STATE OF NORTH CAROLINA
DEPARTMENT OF TRANSPORTATION

Addendum No. 1

RE: Contract ID C202821

Bridges Over Church Creek And Approaches On SR-1004; Intersection
Improvements At SR-2360 (Oddie Road)

UO-2 4

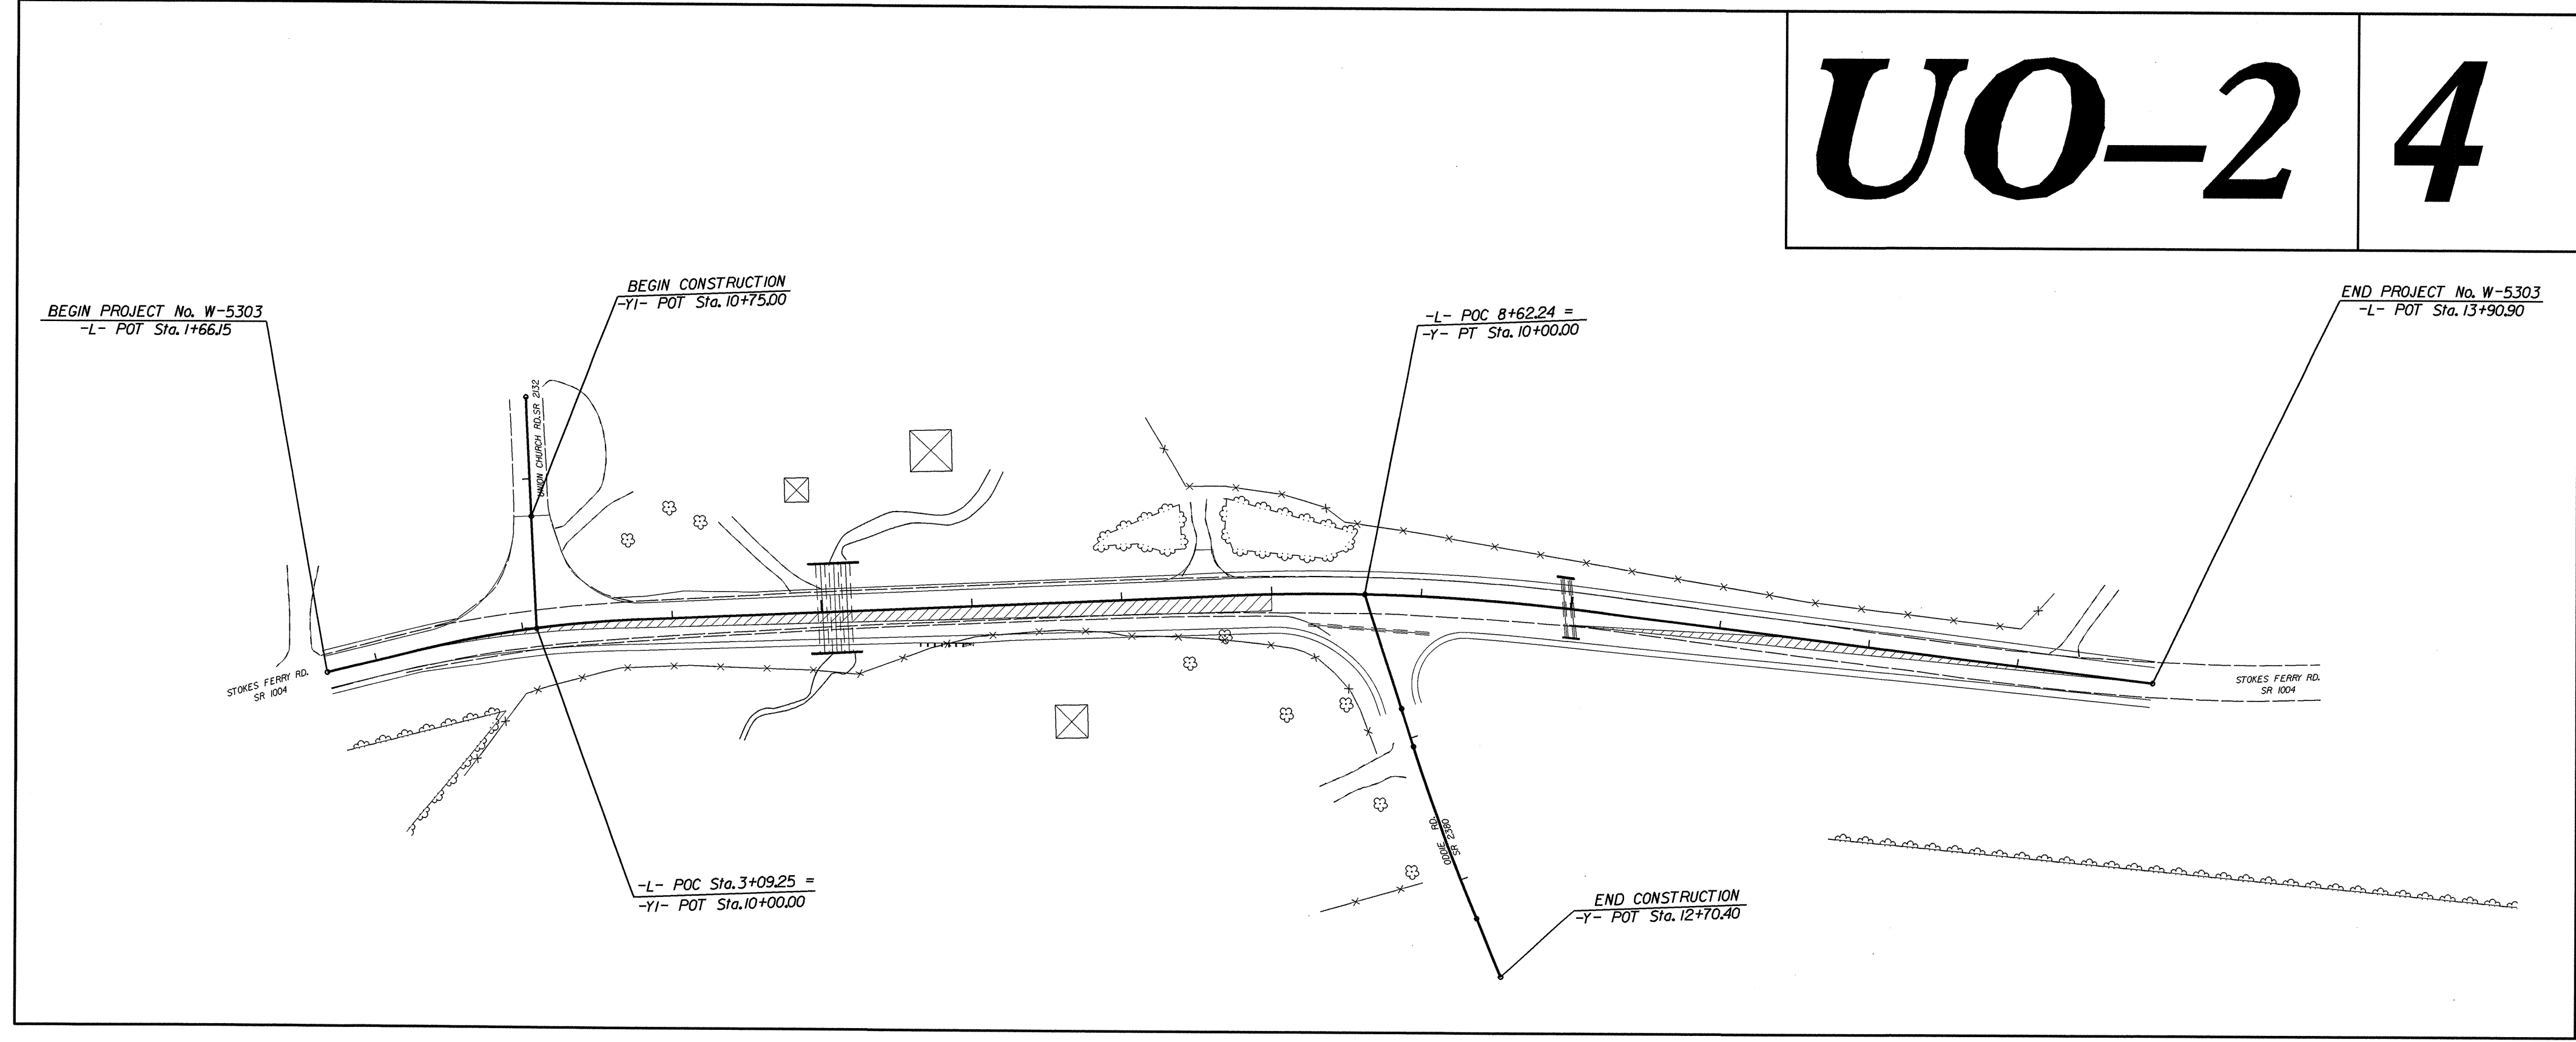
Sheet Nos. UO-2 (W-5303), UO-2 and UO-3 (B-4257) have been revised to include the correct parcel number designations. Please void Sheet Nos. UO-2 (W-5303), UO-2 and UO-3 (B-4257) in your plans and staple the revised Sheet Nos. UO-2 (W-5303), UO-2 and UO-3 (B-4257) thereto.
